Please ask for: Sian Eggington
Email: sian.eggington@terraquest.co.uk
Telephone: 0121 234 1390
Our Ref: FP/264/21/HH
Your Ref:
Date: 23rd December 2021

Application for Planning Permission for Works or Extension to a Dwelling

Development: Single storey side and rear and conversion of garage to habitable use.
Location: 21 South Drive Felpham PO22 7PY

Mr & Mrs Ivens
21 South Drive, Bognor Regis
EXISTING GROUND FLOOR

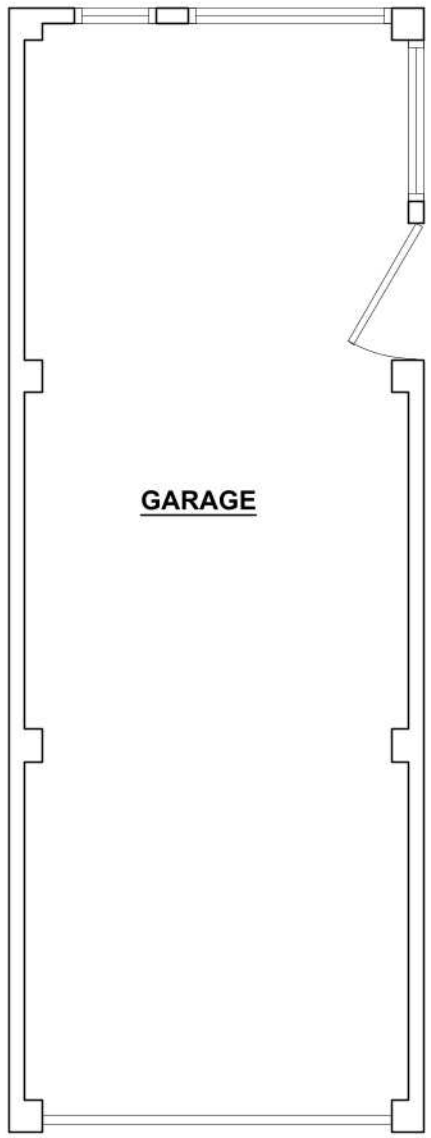
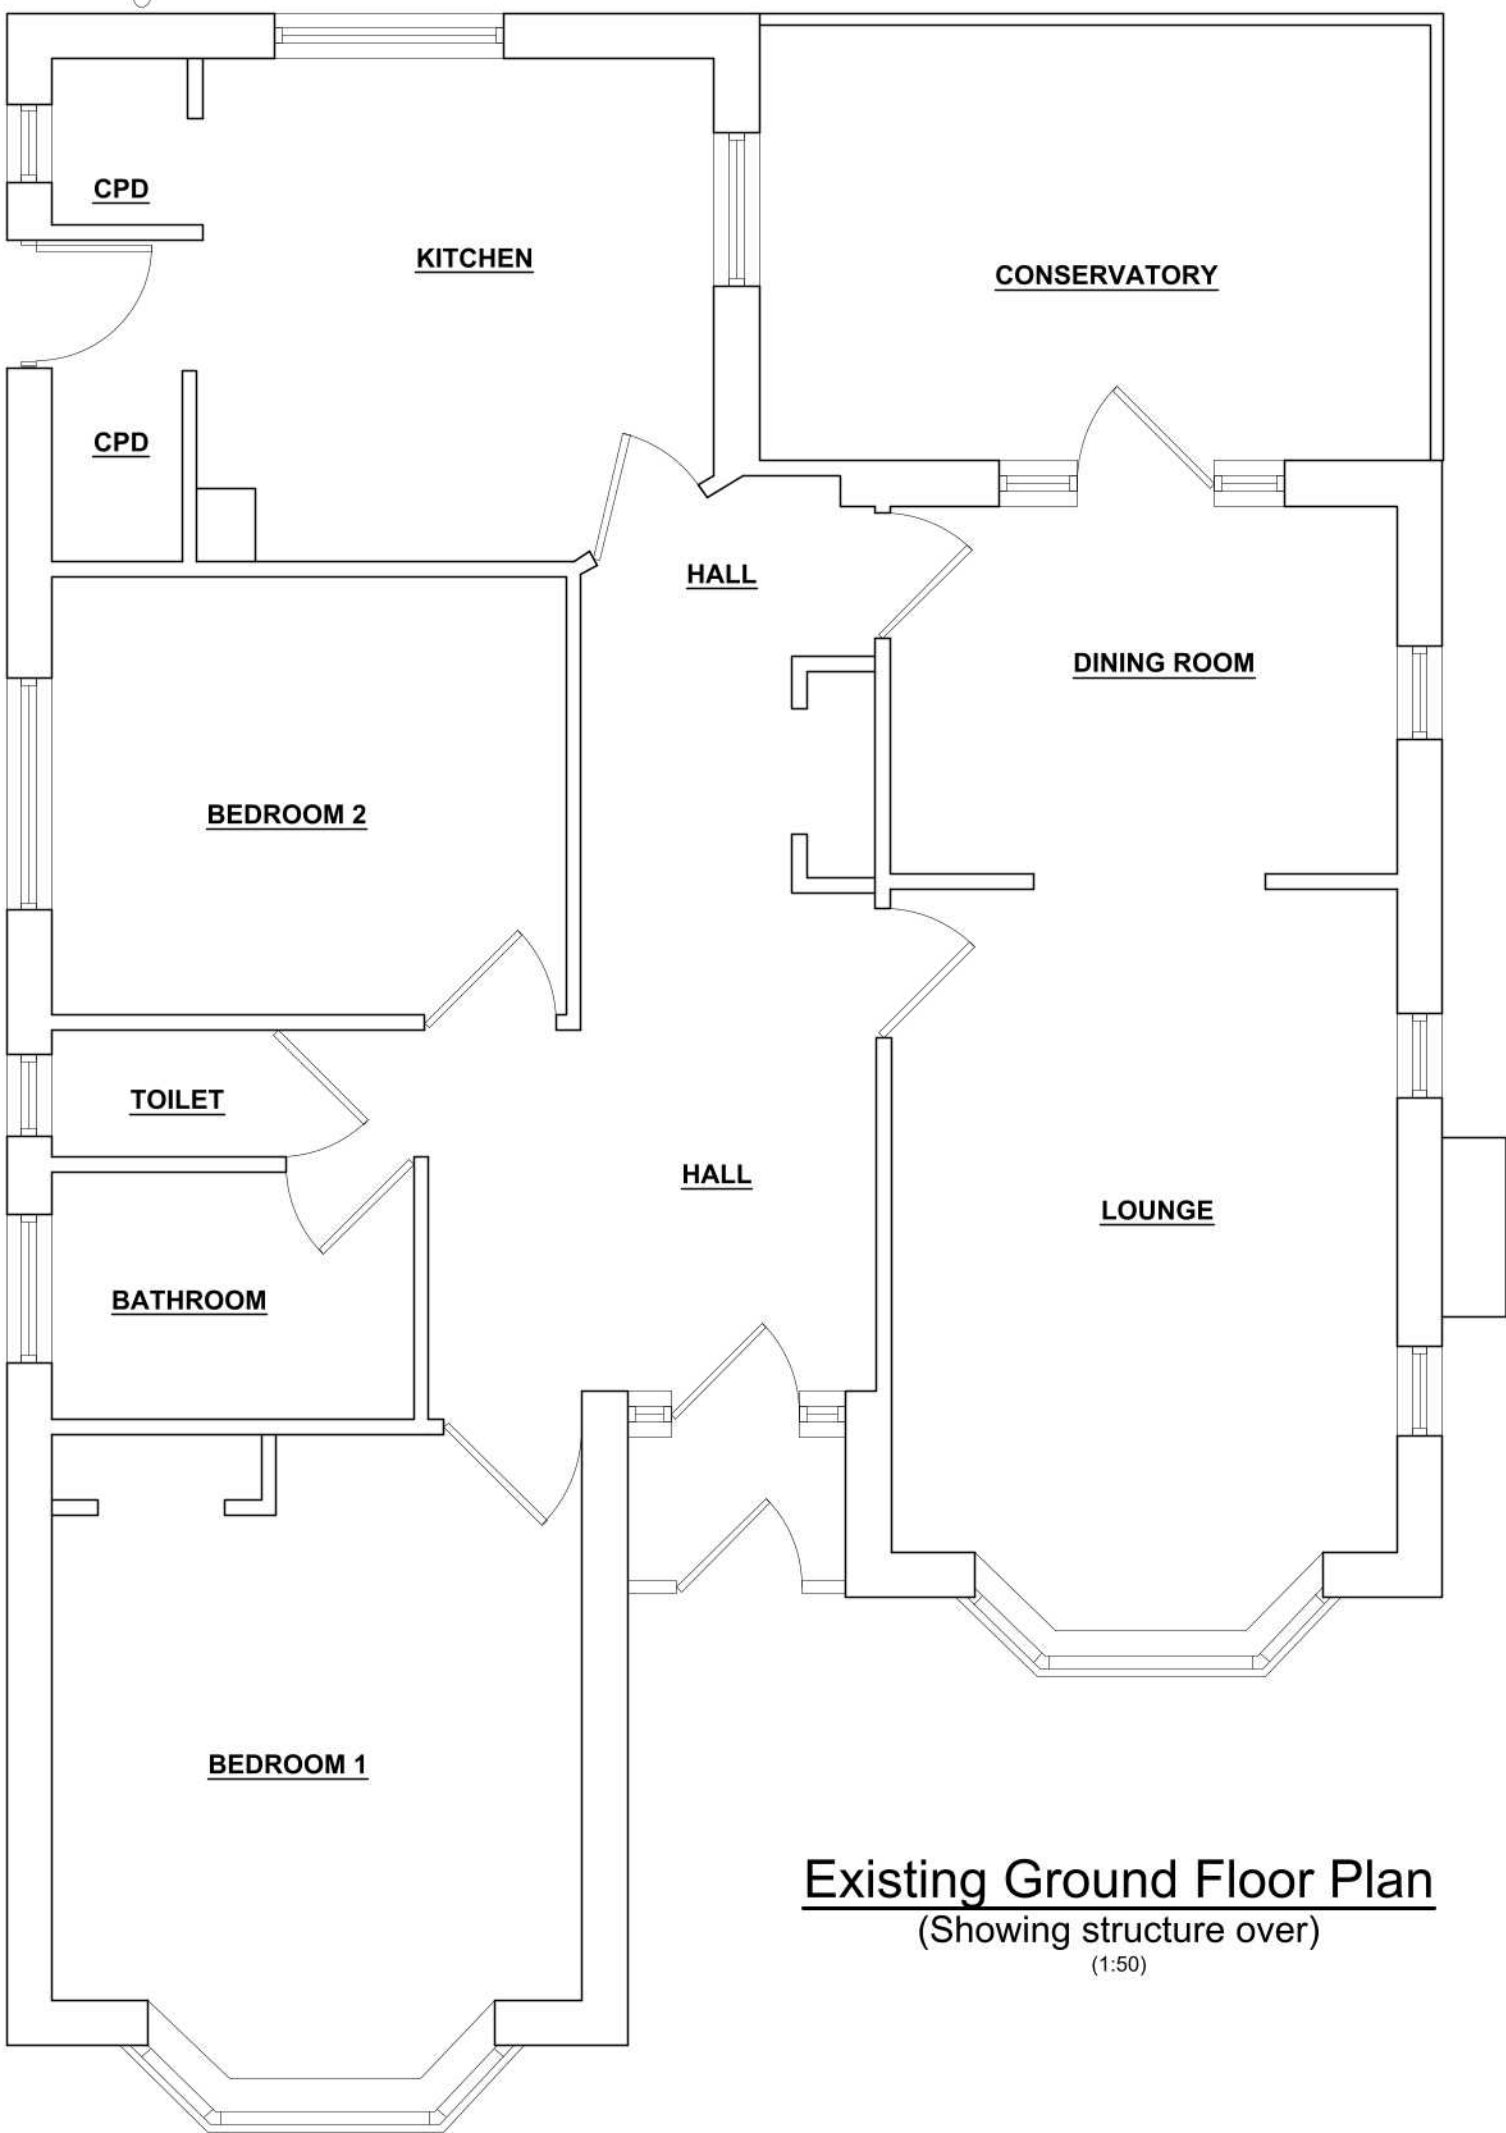
Please submit 1 electronic or 3 paper copies of clearly labelled existing floor plans at a scale of 1:50 or 1:100. Further details can be found in the Validation Requirements List.
